Sandra Mullett from GREAT MOULTON

LIST OF ISSUE-SPECIFIC QUESTIONS – SUBMISSION REFERENCE SBCAF9C09

Figure 7.10  
Public Right of Way Receptors Plan  
Sheet 1

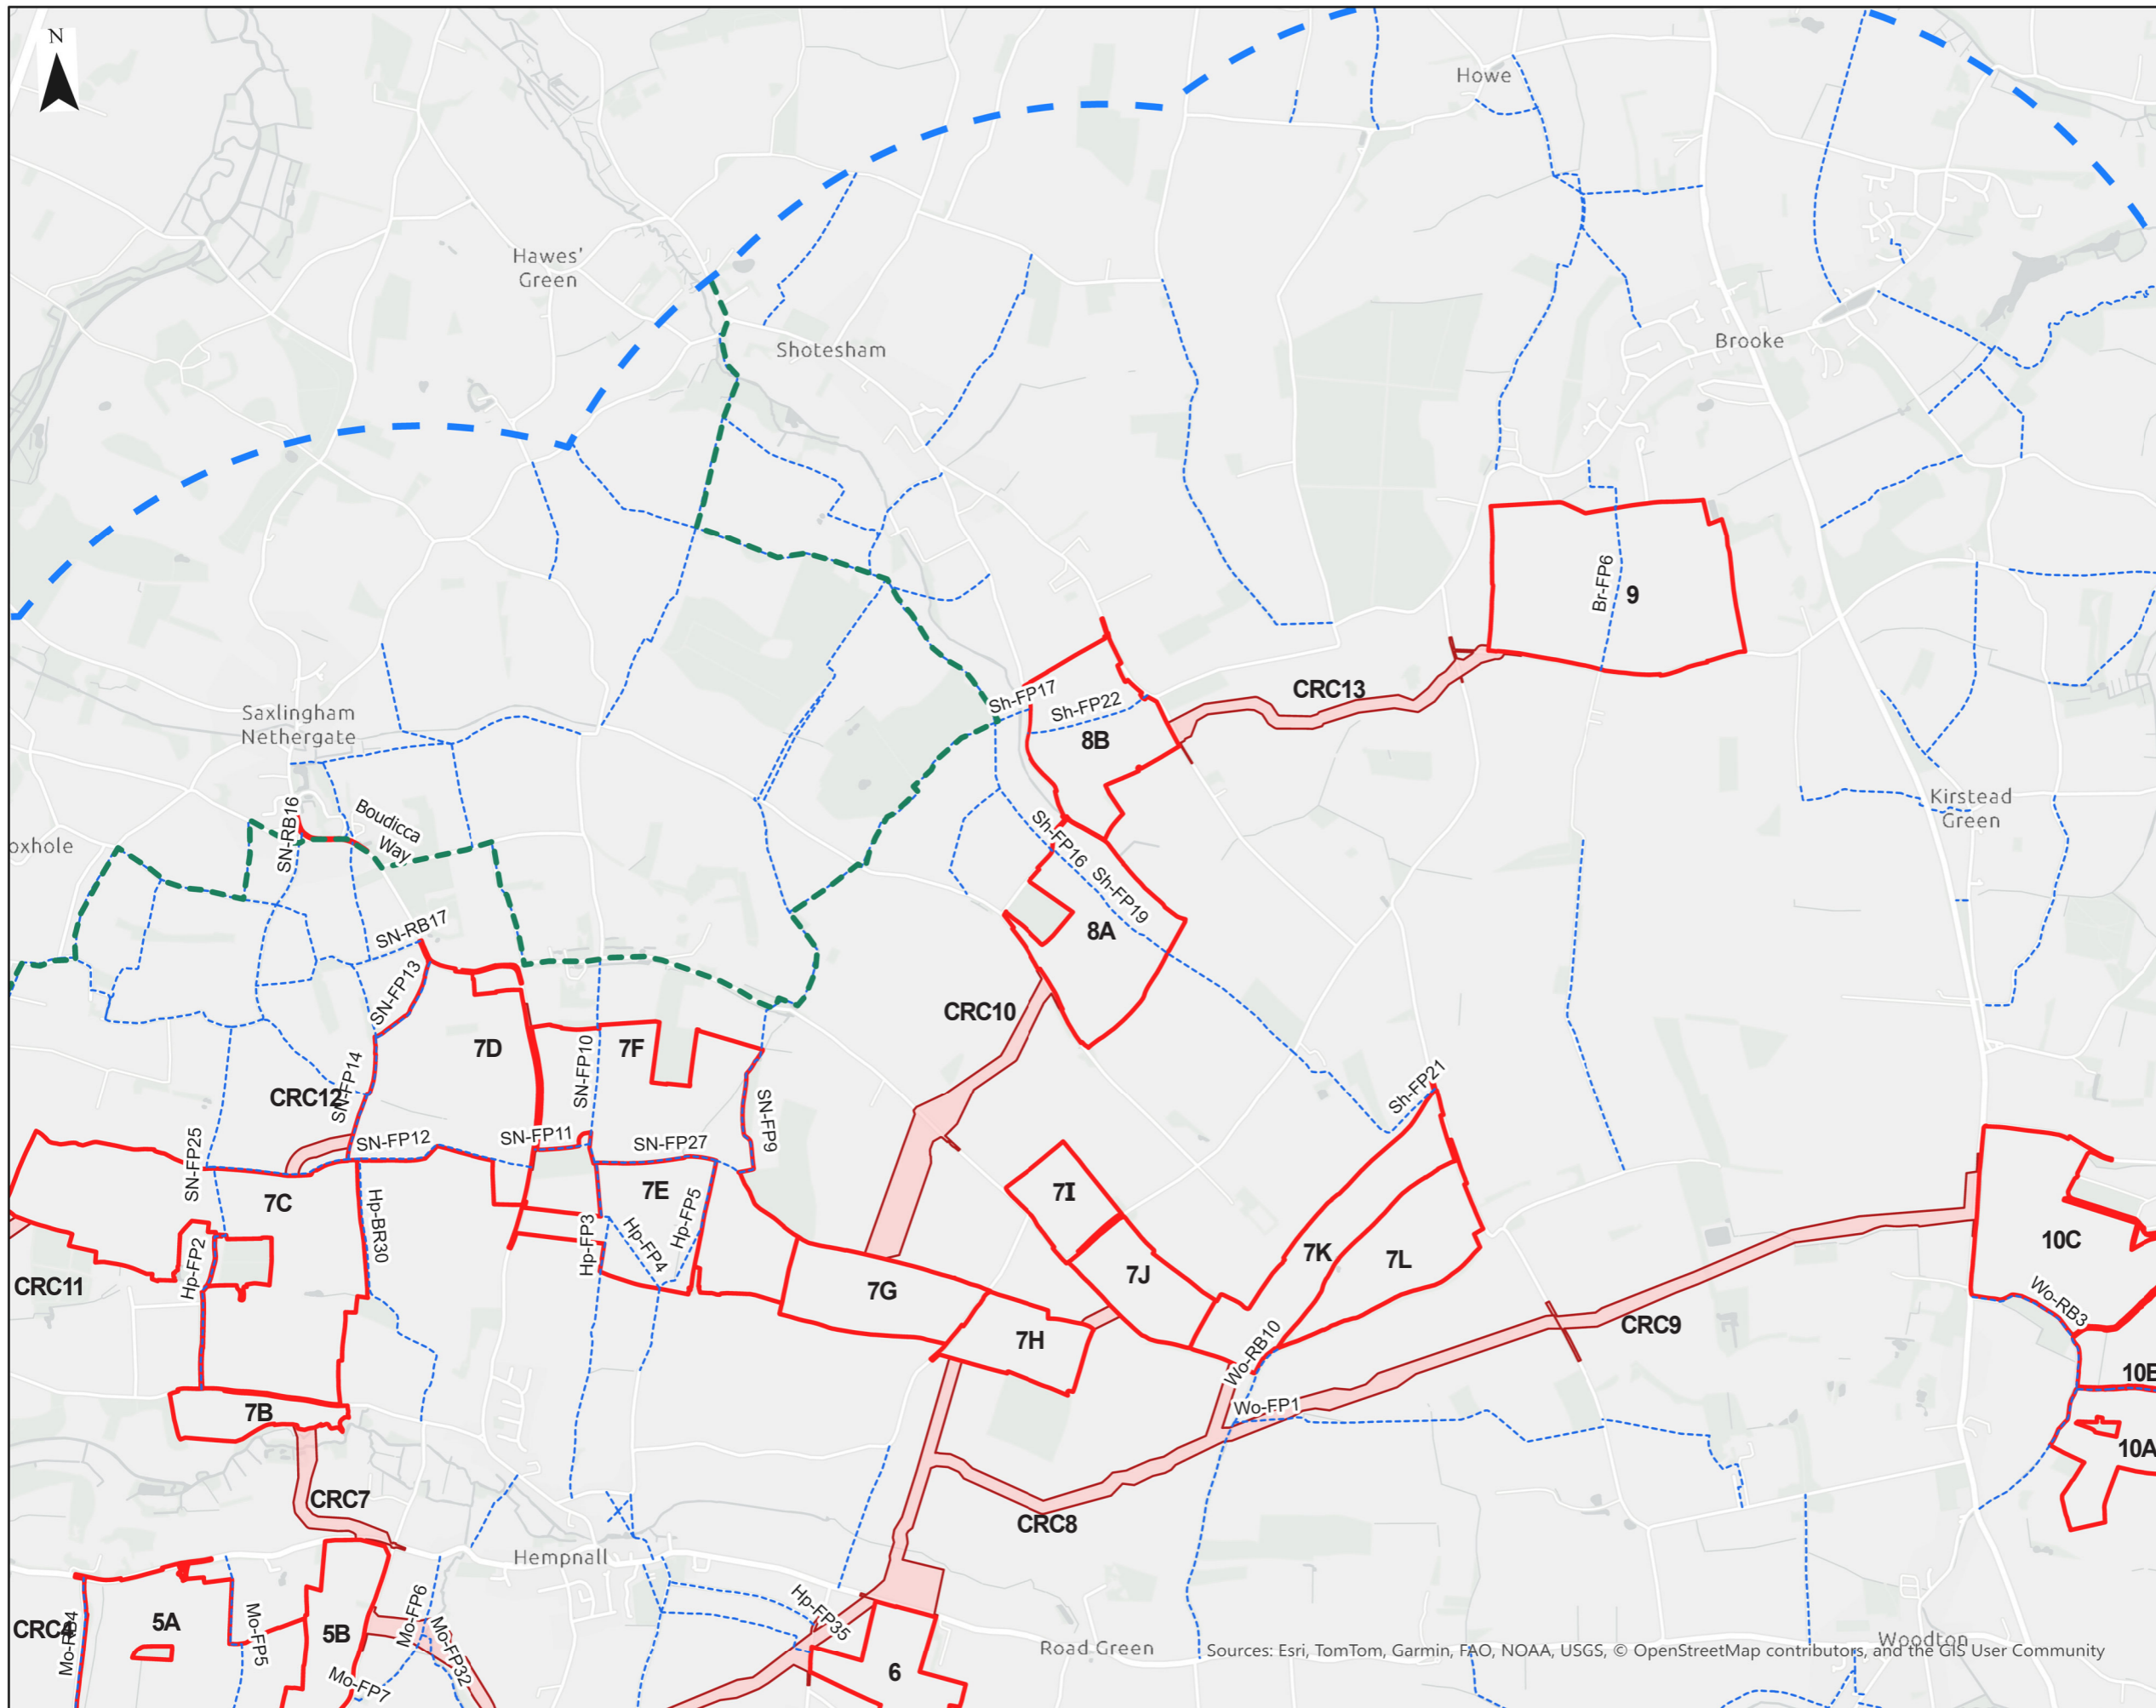
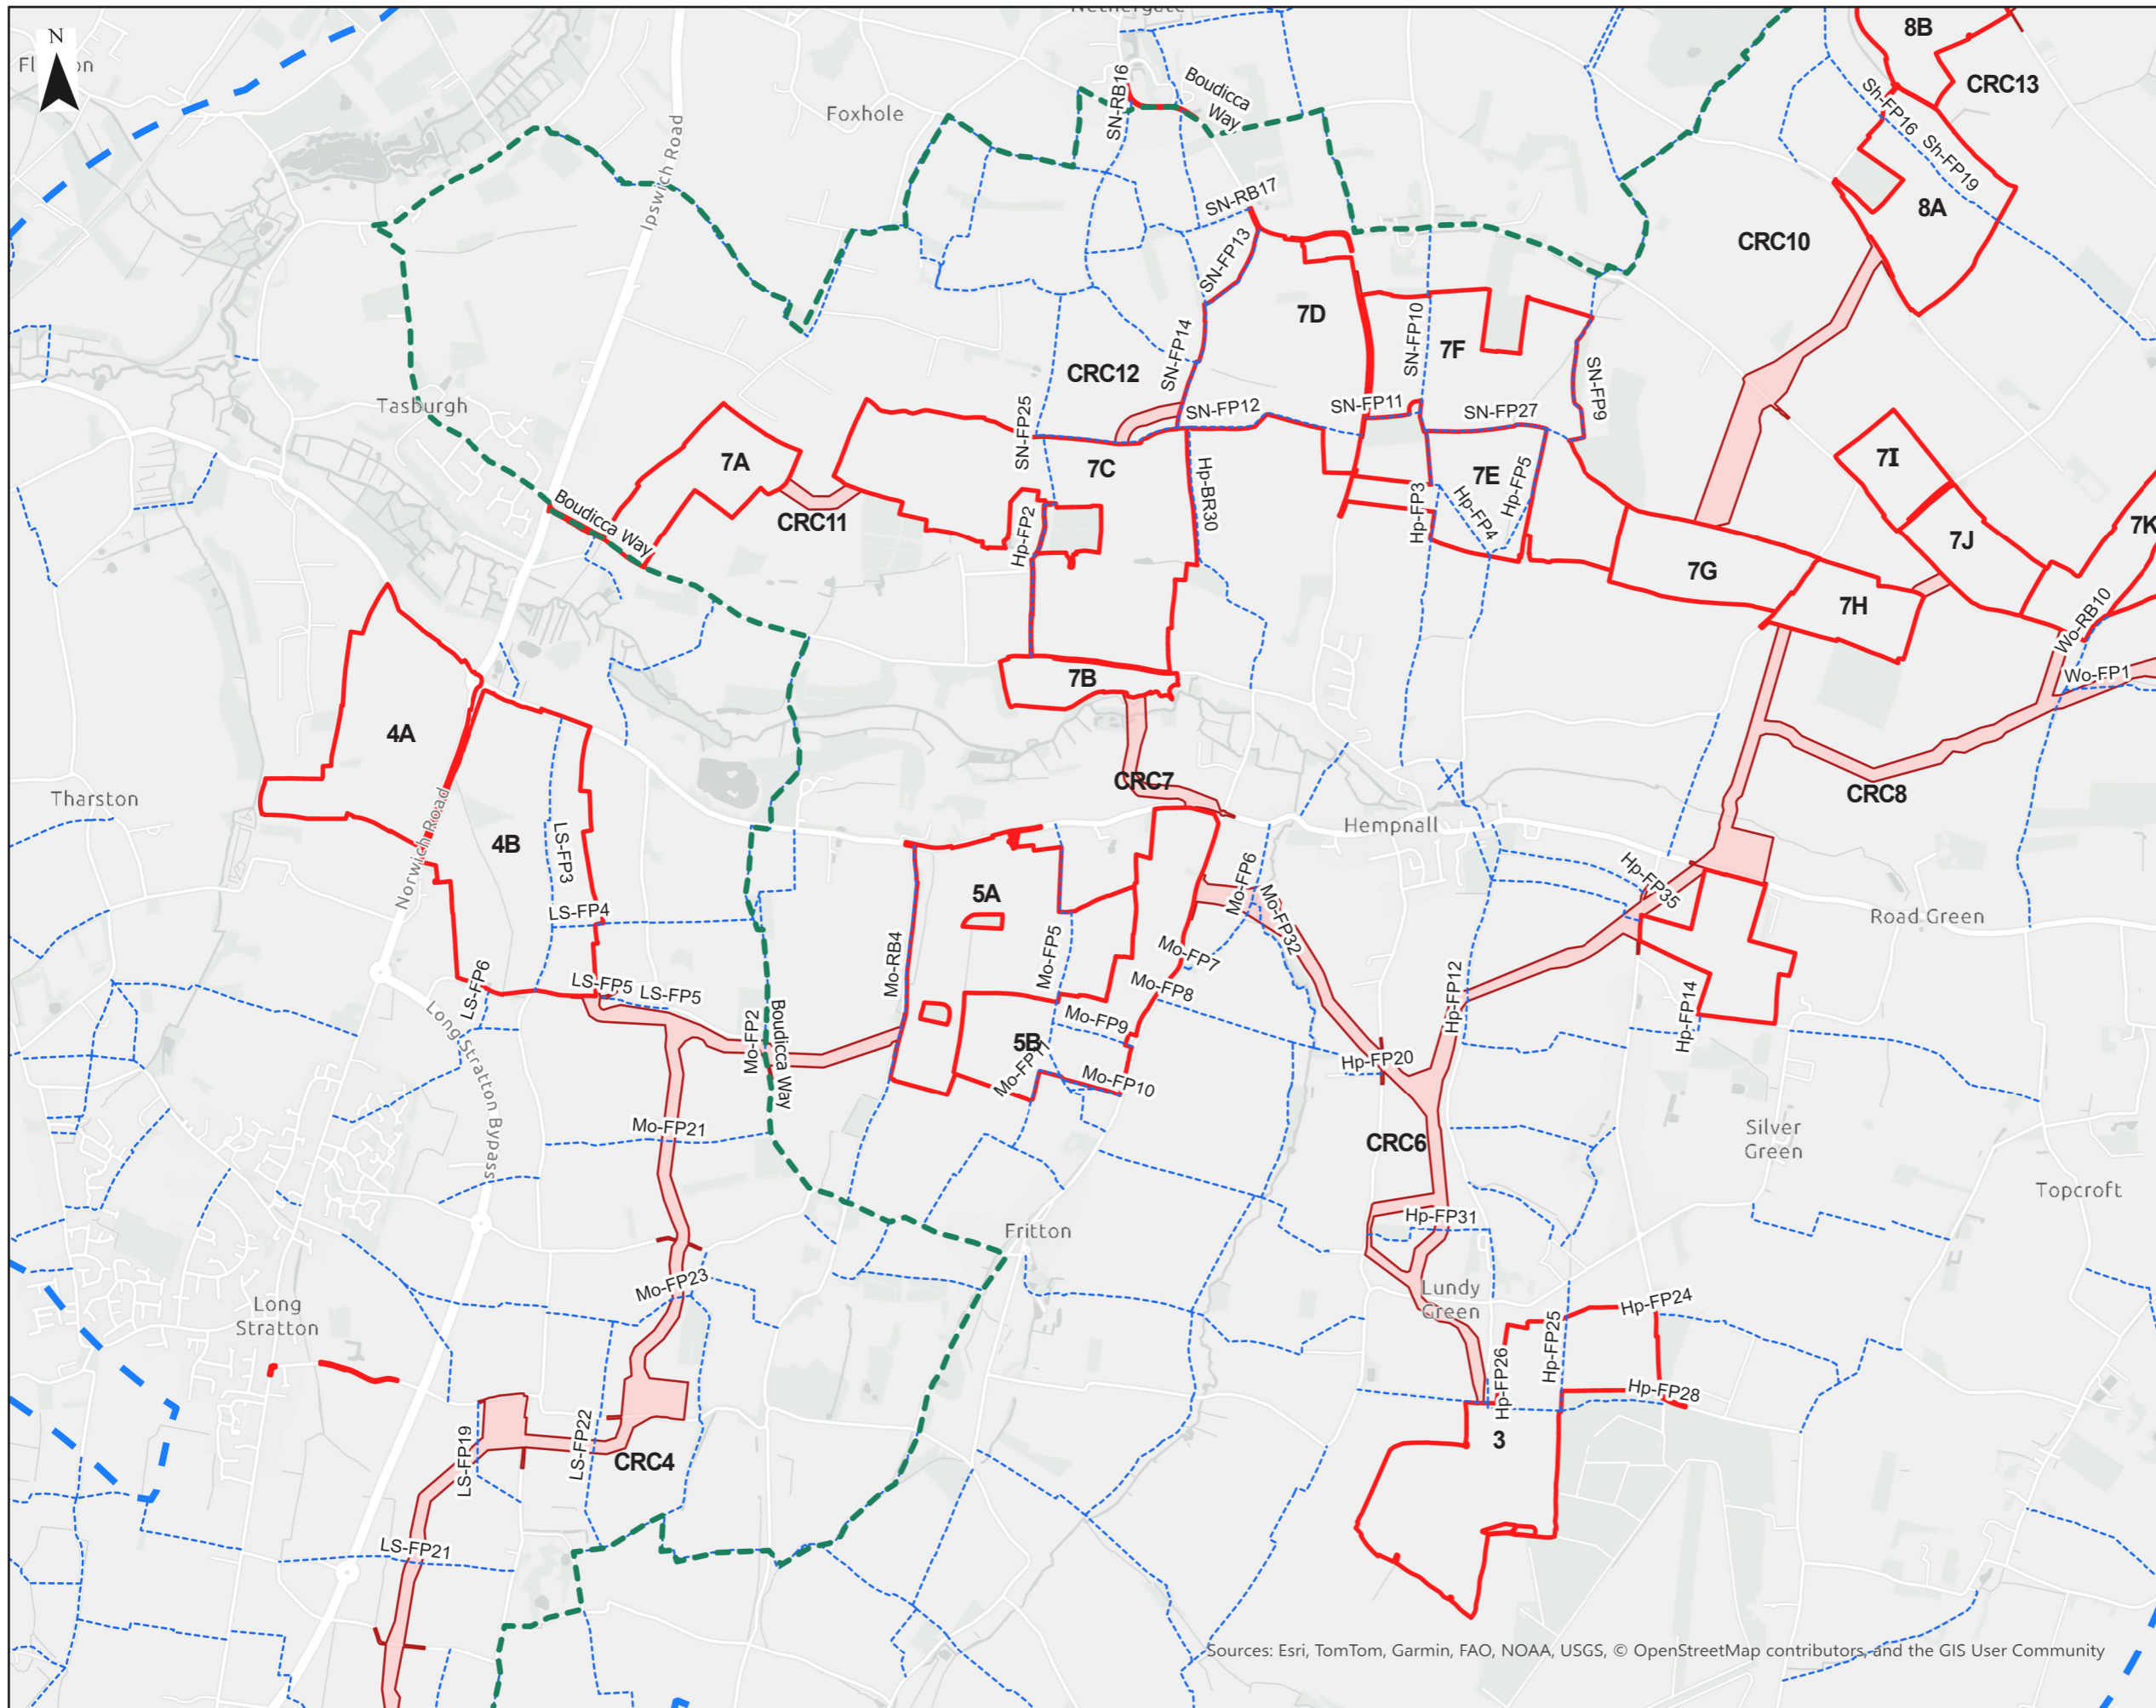
3. Hundred Lane/RB19 – Permanent Haul Route and Maintenance Crossing

- i. What changed between the PEIR access strategy and the final DCO design to make a permanent engineered crossing of Hundred Lane/RB19 is now necessary?
- ii. Why can A03/Frith Way and the previously identified Lodge Road/Frith Way arrangement not meet the operational needs, whether by continued use, adaptation or shared accesses?
- i. What alternatives were considered specifically for the Hundred Lane crossing, and where is the comparison showing that reasonable alternatives would not avoid or materially reduce the acknowledged Significant harm to RB19?
- iii. When was the permanent Hundred Lane crossing first added into the Scheme design, and where and when were affected residents and users of RB19 clearly consulted about the haul-route crossing remaining as permanent maintenance access?

3.2 If the crossing is intended to remain after Year 60 to serve the National Grid Substation or Grid Connection Infrastructure, **why is that potentially indefinite effect not been clearly identified and assessed as permanent infrastructure associated with the retained transmission asset?**

Before the Hundred Lane crossing be authorised as a permanent infrastructure, The Applicant should set out why it is operationally necessity, the vehicle types, likely frequency of use, exact width and surfacing, and why the same function cannot be achieved through existing access points?
